**MODIFICATION REQUEST
Former Sunbeam Factory
60 Charlotte Street Campsie
MP07_0106 & MP08_0087 MOD 1**

Director-General's
Environmental Assessment Report
Section 75W of the
Environmental Planning and Assessment Act 1979

December 2011

DRAWING TITLE
**LEVEL 01
FLOOR PLAN**

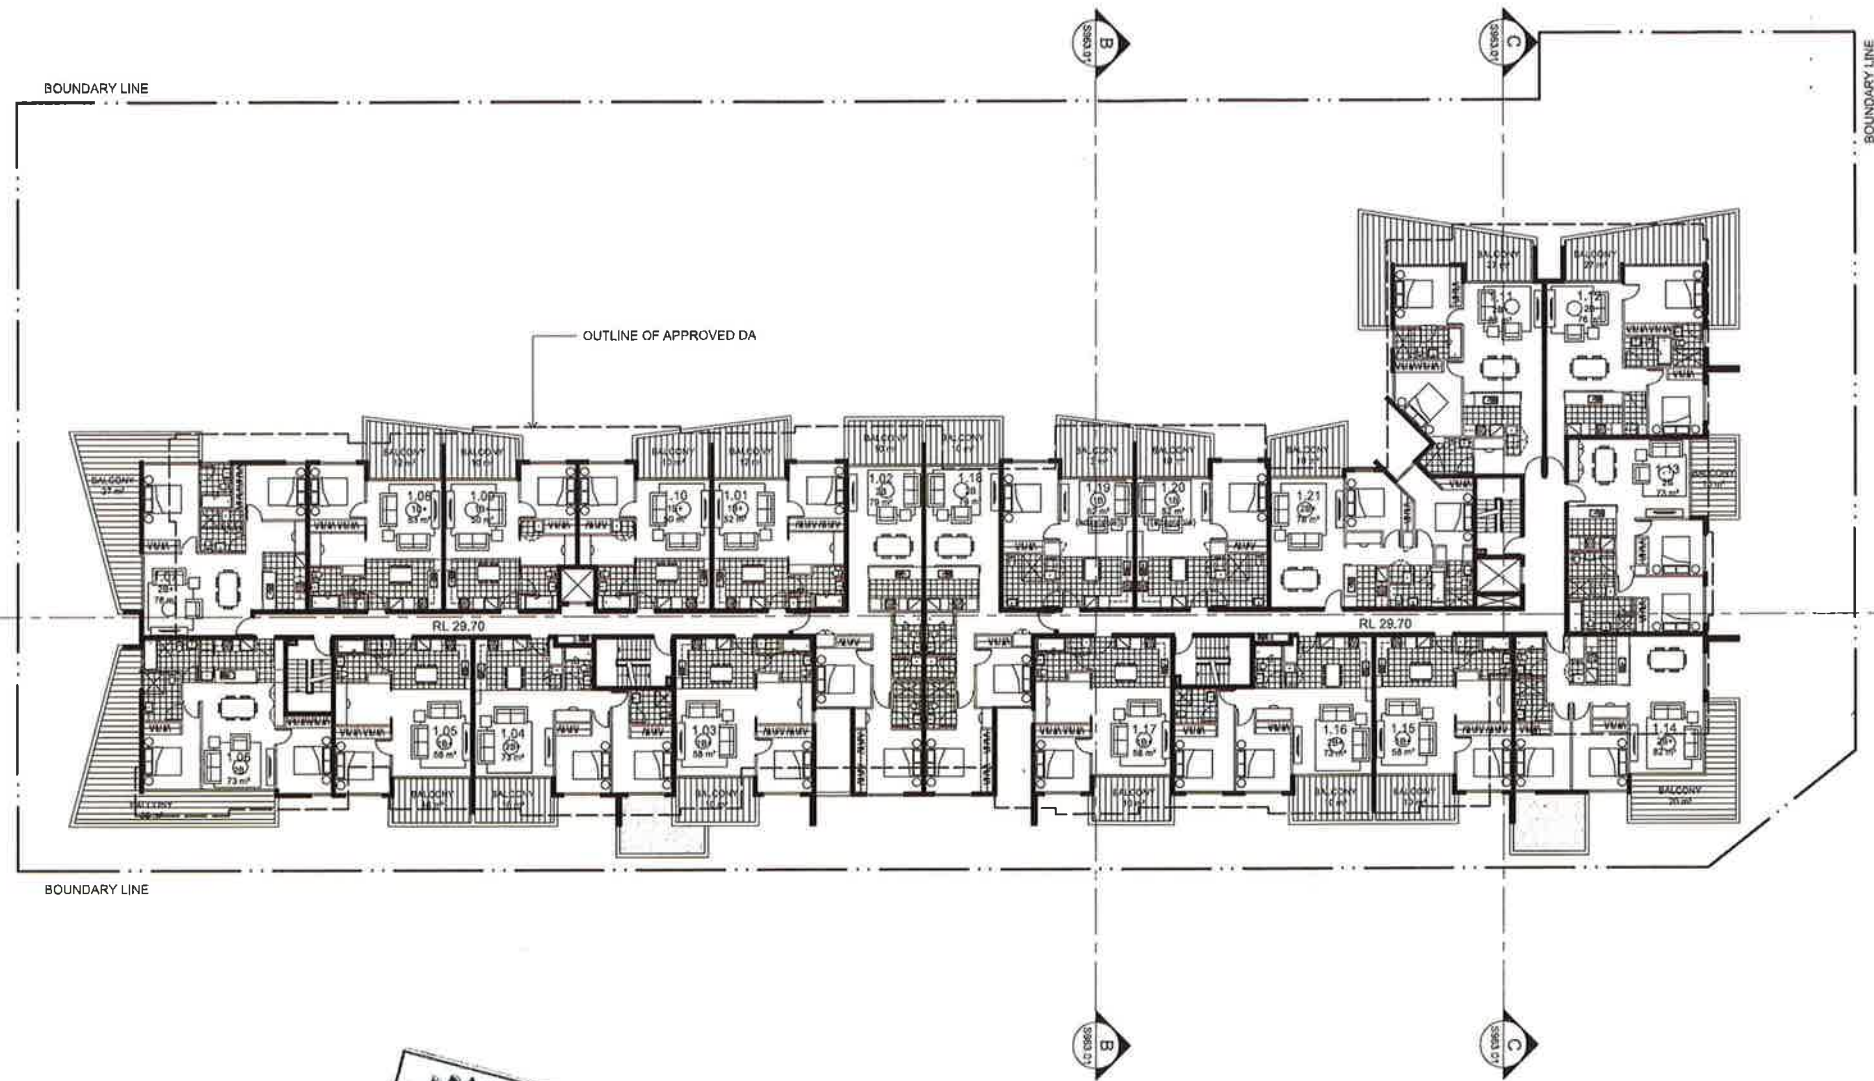
The modification proposes to amend condition B34 which requires fixed upward facing louvres to be attached to the top of the balustrade of **all balconies** facing the northern elevation. The modification proposes louvres to be only fitted to the balconies at the north-eastern corner of the building, as these are the only balconies that are likely to result in any overlooking of neighbouring properties.

The setback of the balconies from the boundary at the north-east corner will be reduced from approximately 6.5 metres to approximately 5.8 metres. As illustrated by **Figures 4 and 5**, the reduced separation sought in the modified layout will impact upon the privacy of neighbouring

residential properties. The Department therefore considers it necessary to retain the louvers (as required by Condition B34 of the approval) on this part of the building and only for levels 1 to 3. The Department considers the proposed landscaping and boundary fencing is adequate to prevent direct overlooking at ground level. The condition will be amended as follows:

*'Fixed upward facing louvers must be attached to the top of the balustrade of all of the balconies on the northern **north-east corner** elevation of the building **for levels 1- 3 (6 units)** on proposed Lot 11. The louvers must extend to the underside of the ceiling of the balcony, and must be sliding to cover a minimum 50% of the width of each balcony of the building to protect neighbours' privacy'*

NORTH ELEVATION

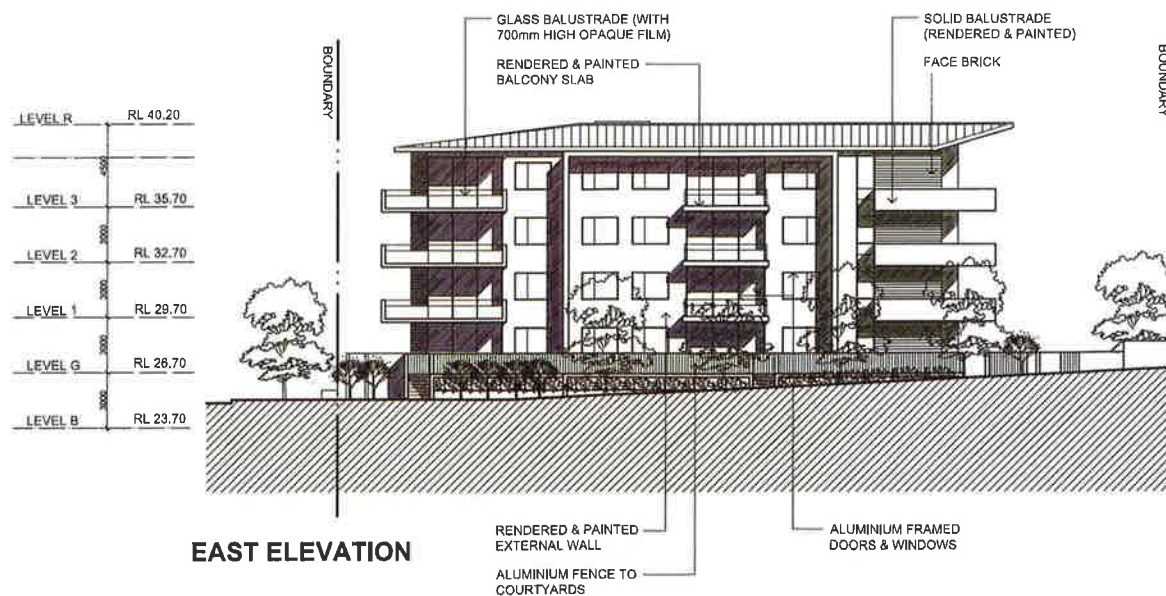
The modification will slightly alter the approved building envelope including a 0.69 metre increase in the overall building height. The majority of changes result from increased articulation to the building's façade, the enlargement/alteration of the balconies and a slight protrusion of the proposed basement. The protrusion of the basement is however less than 1.2 metres above ground level and will not be visible from the public road way.

The modifications will extend the building approximately 1 metre closer to the northern boundary (Sunbeam Lane) and 5 metres closer to the western boundary (Troy Street). The proposed encroachments into the approved building setbacks are limited to balcony projections, with the building's façade largely remaining within the approved building envelope. Where balconies extend beyond the approved building envelope, they remain setback a sufficient distance to generally comply with RFDC separation requirements and do not substantially alter the approved building envelope. The changes add more interest to the external appearance of the building and the floor area of the building will remain unchanged. The proposed building modifications are therefore supported.

PRECINCT B LANDSCAPE PLAN

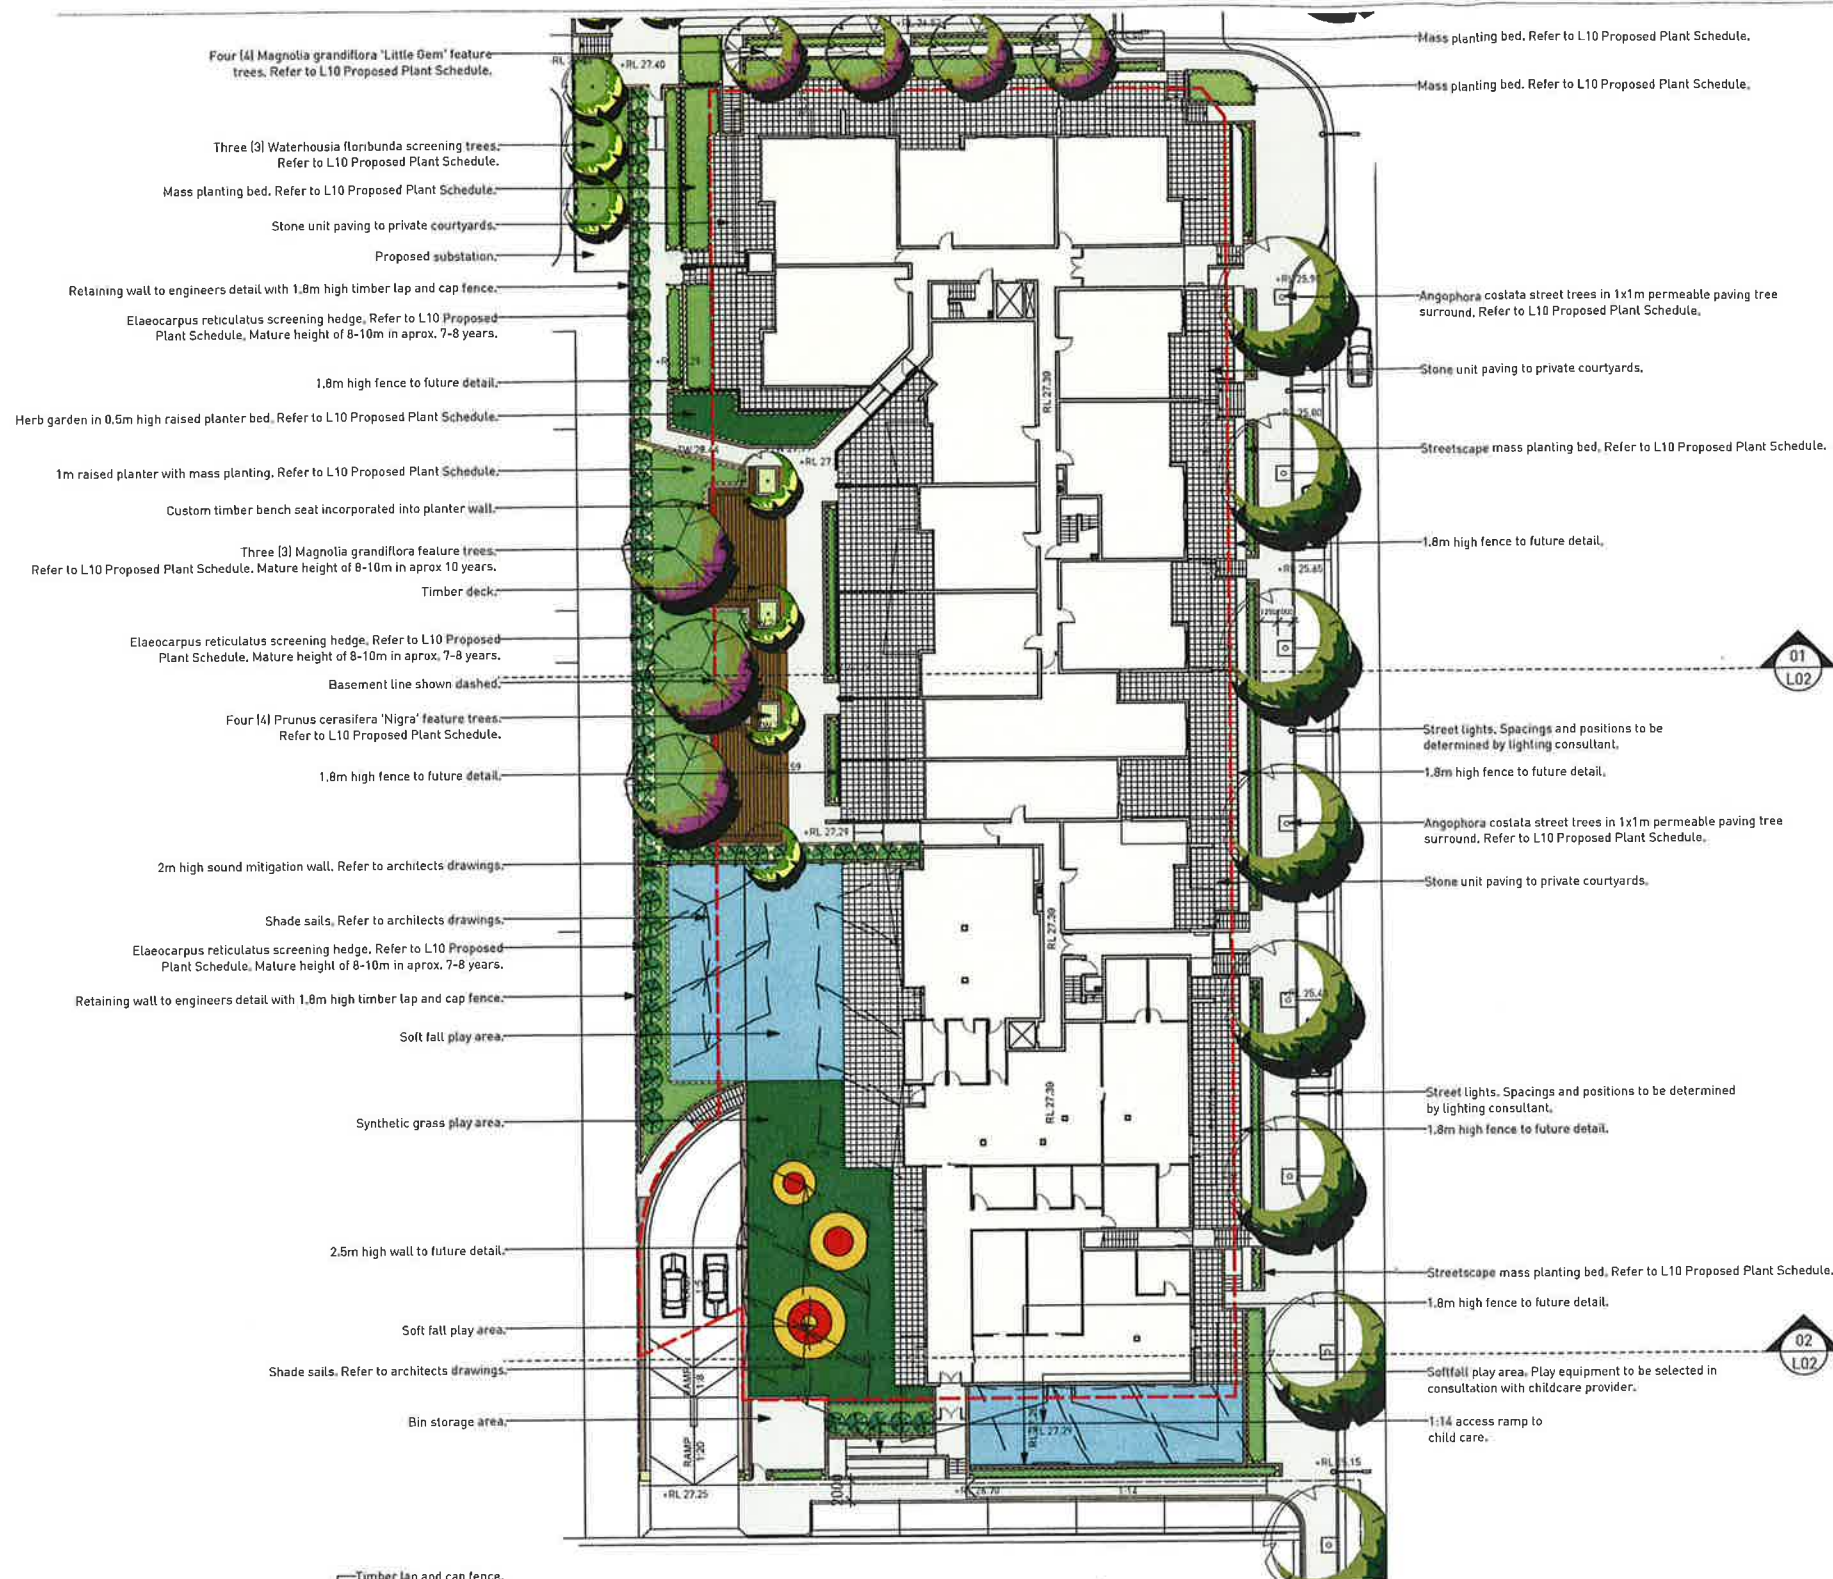
The landscaping plan has been amended to correspond to the altered building layout and generally involves the reconfiguration of planting beds, trees and pathways. The modification to landscaping also includes the introduction of a 2 metre high sound mitigation wall, increasing the height of the boundary fence from 1.6 metres to 1.8 metres and the relocation of an electricity substation.

A sound mitigation wall is proposed to be erected midway along the western side of the building. The wall will separate the play area of the childcare centre and the residential communal open space. The wall will allow for enhanced acoustic privacy, will be landscaped and will not be visible from the street or adjoining properties.

The approved substation measured approximately 3 x 6 metres and was located in the north-east corner of the Stage 1 site at the southern end of Wade Street. The modification includes reducing the size of the substation to approximately 3 x 3 metres and moving it approximately 3 metres to the west. Access to the substation will remain from Wade Street and the reduced size will allow for additional landscaping thereby reducing its visual impact upon the locality (**Figures 6 and 7** illustrate the repositioned Substation).
